Application number: 2023/91280	
What is the application for?:	Quarrying operations for the extraction of clay, shale and incidental coal and s
Address of the site or building:	Bromley Farm Quarry, Barnsley Road, Upper Cumberworth, Huddersfield, HD8 8PD
Postcode:	S36 4HG

I am writing to formally object to the proposal for the Bromley Farm Quarry (Ref: 2023/91280).

ACCESS TRACKING

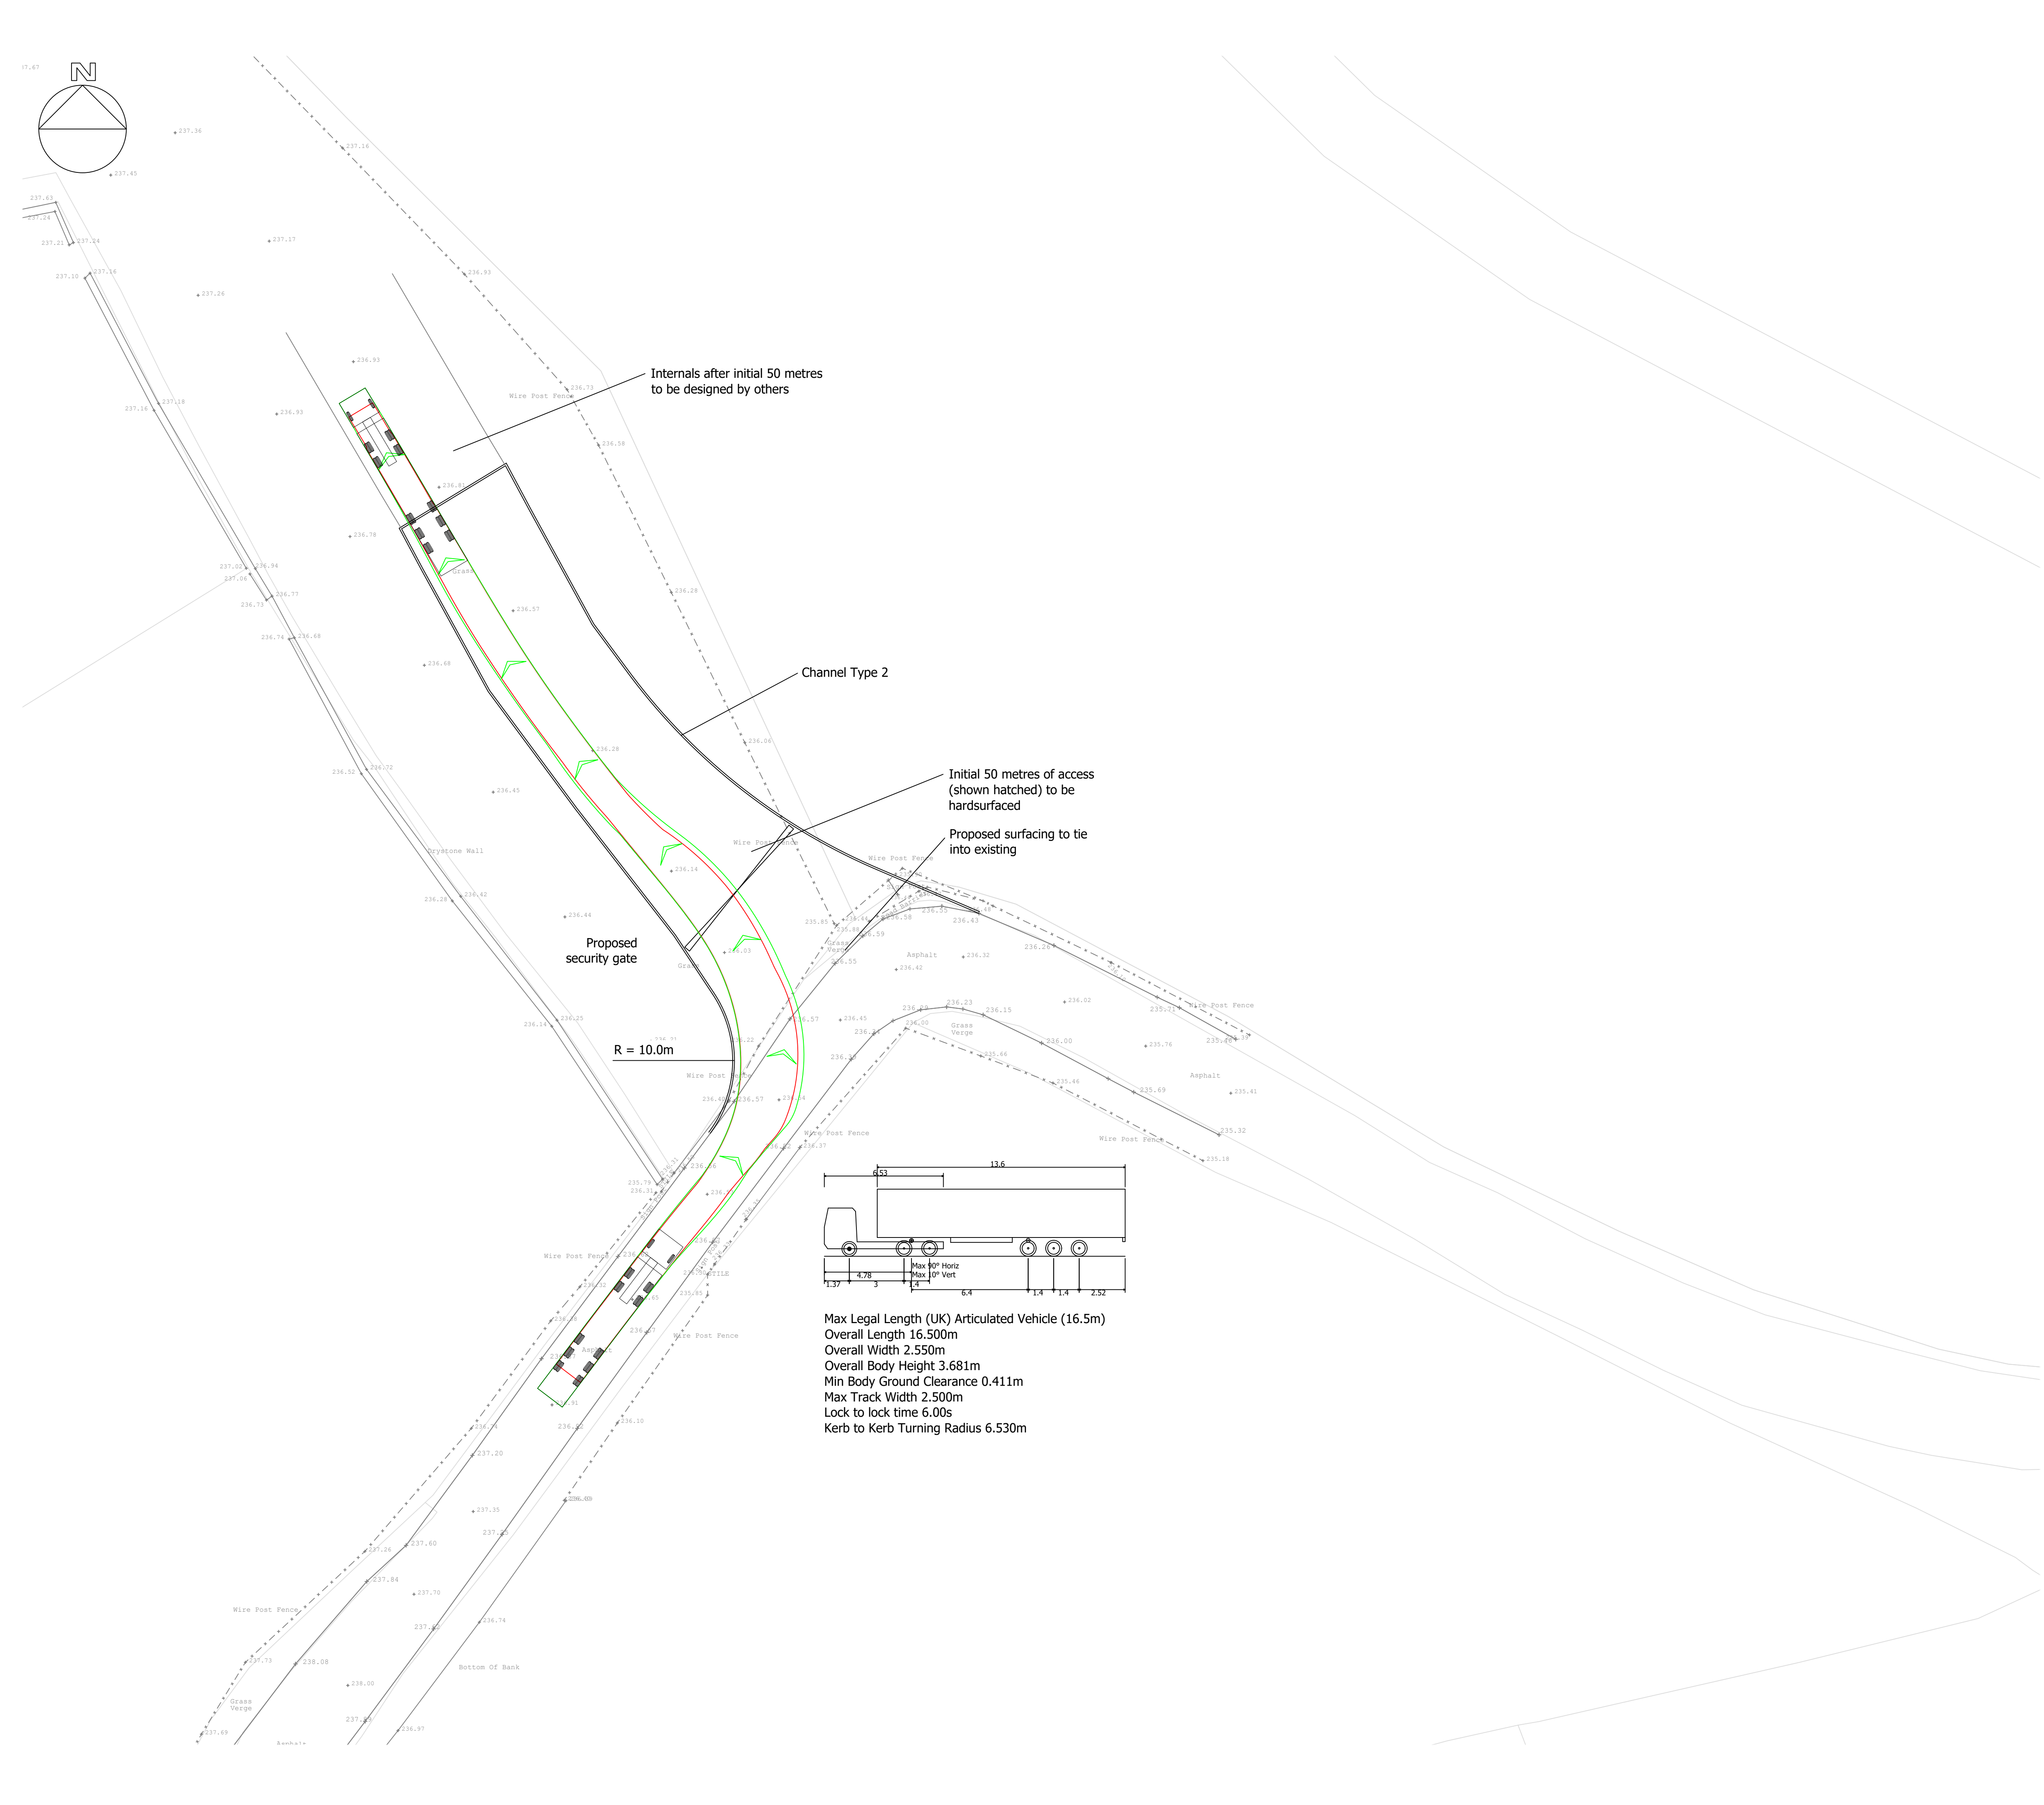
The adequacy of the access road and the kerb radius also raises safety concerns. The recommendation of a 6m wide road is incorrect and does not meet the minimum acceptable width of 8.92 meters as stated by the Health & Safety Executive. Risk assessments should be conducted to ensure the safety of all road users.

Figure B1: HDVs Haulage Route**Figure B2: Spatial modelling scope including verification site and the receptors**

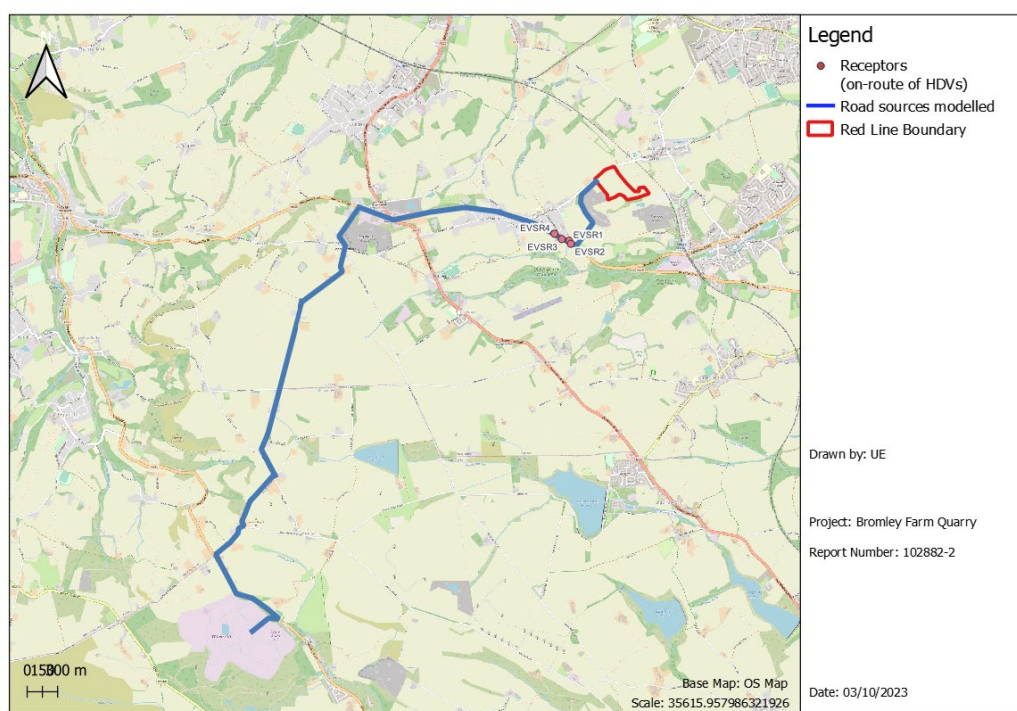
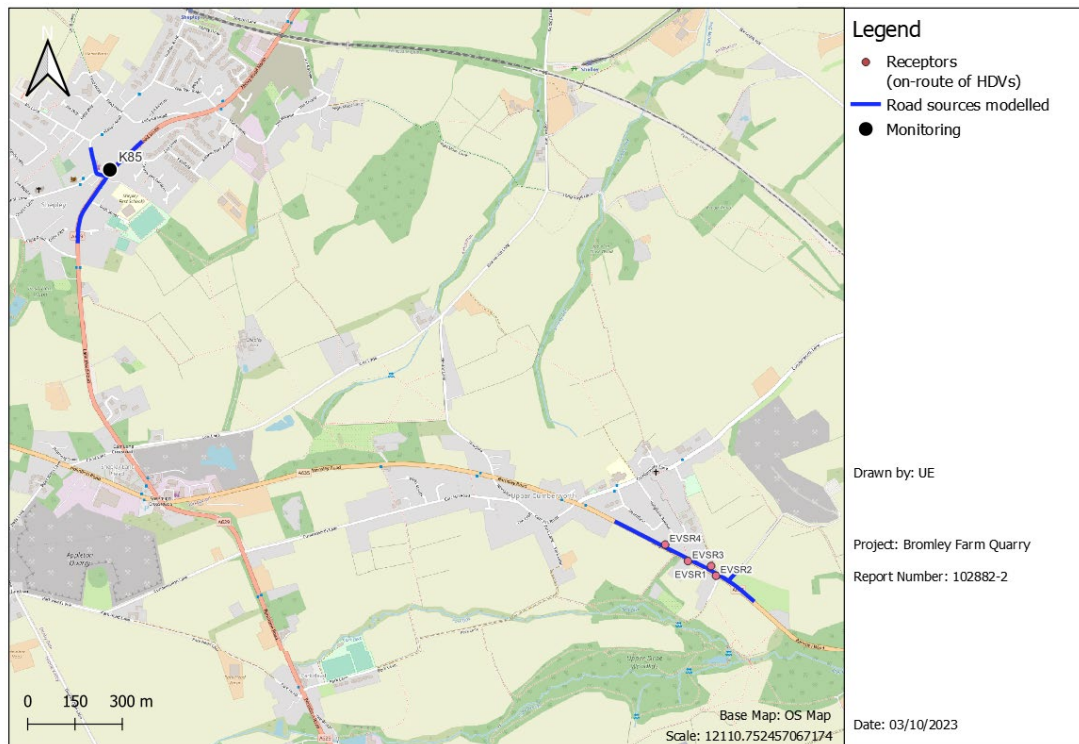
Furthermore, the traffic survey data used is outdated and inaccurate. A detailed survey conducted by the Cumberworth Community in February 2024 provides a more accurate representation of traffic conditions, indicating a significant increase in HGV movements. This data should be considered over the Department for Transport's 2019 data.

Moreover, the proposed transport route does not consider statutory HGV laws and the potential use of unsuitable roads by HGVs. This oversight could lead to increased traffic and safety risks in the community.
